From: [Brenda Larsen](#)
To: [Jeff Watson](#)
Subject: RE: SG-08-00032 Hundley
Date: Wednesday, July 21, 2010 10:27:47 AM

After conducting a review of the above named project, I have the following comments:

PROPOSED

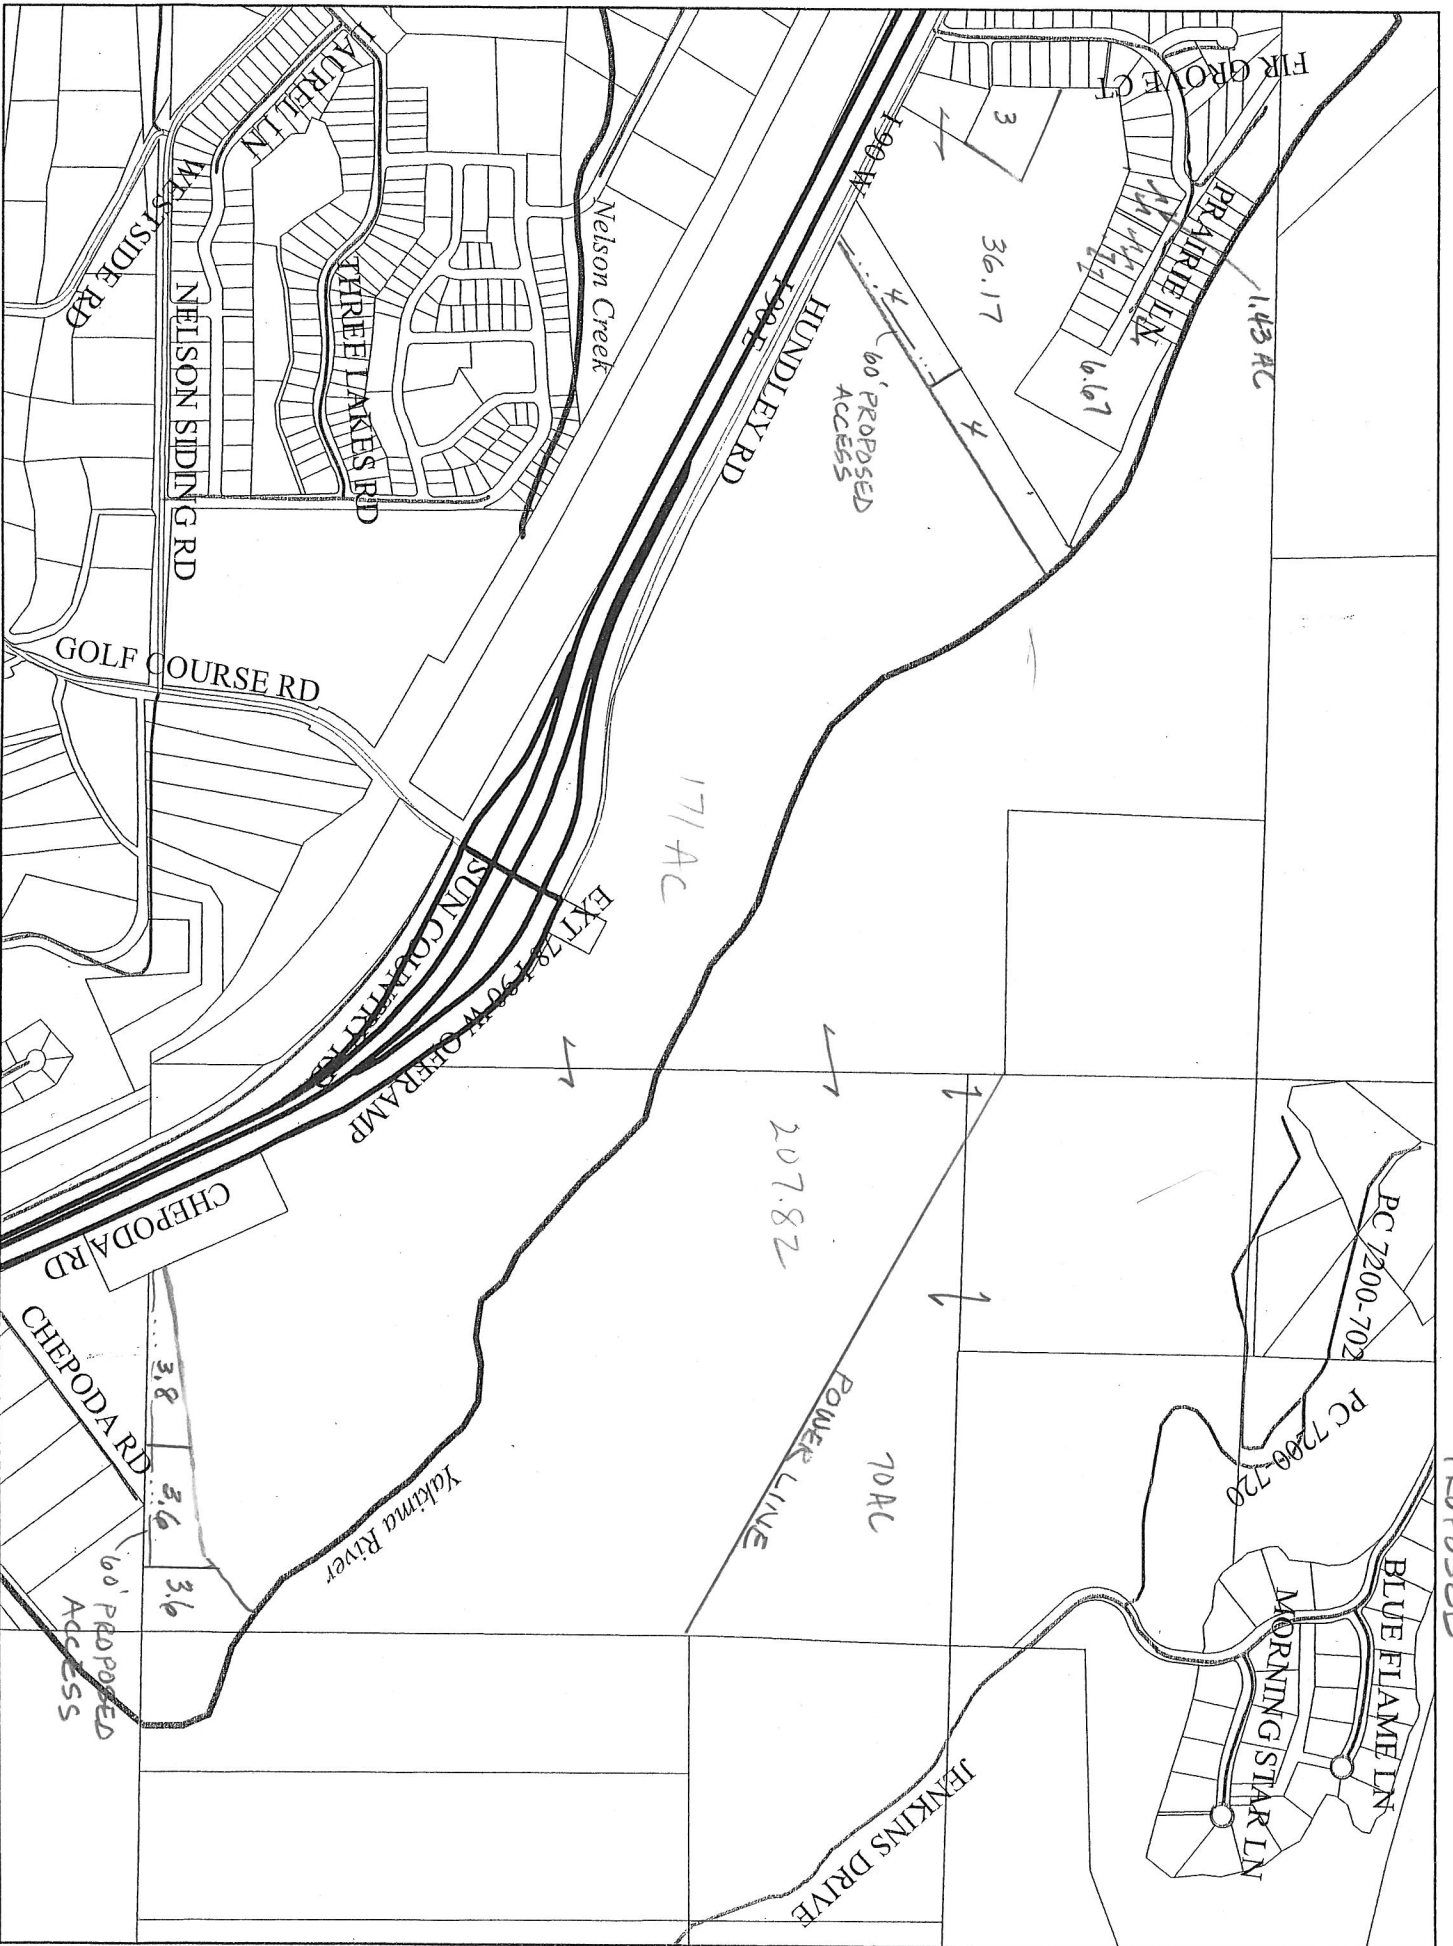
- Ensure that boundary line adjustments do not infringe upon existing structures, to include propane tanks, etc.
- Creation of any additional roads or access must comply with the International Fire Code, i.e. 20 foot wide, all weather surface, slope/grade not greater than 12%, etc.
- Creation of additional lots with future development will require fire flow, water storage tank, water supply system (hydrants), and all other systems as required by code.
- All future development must comply with the International Fire Code.
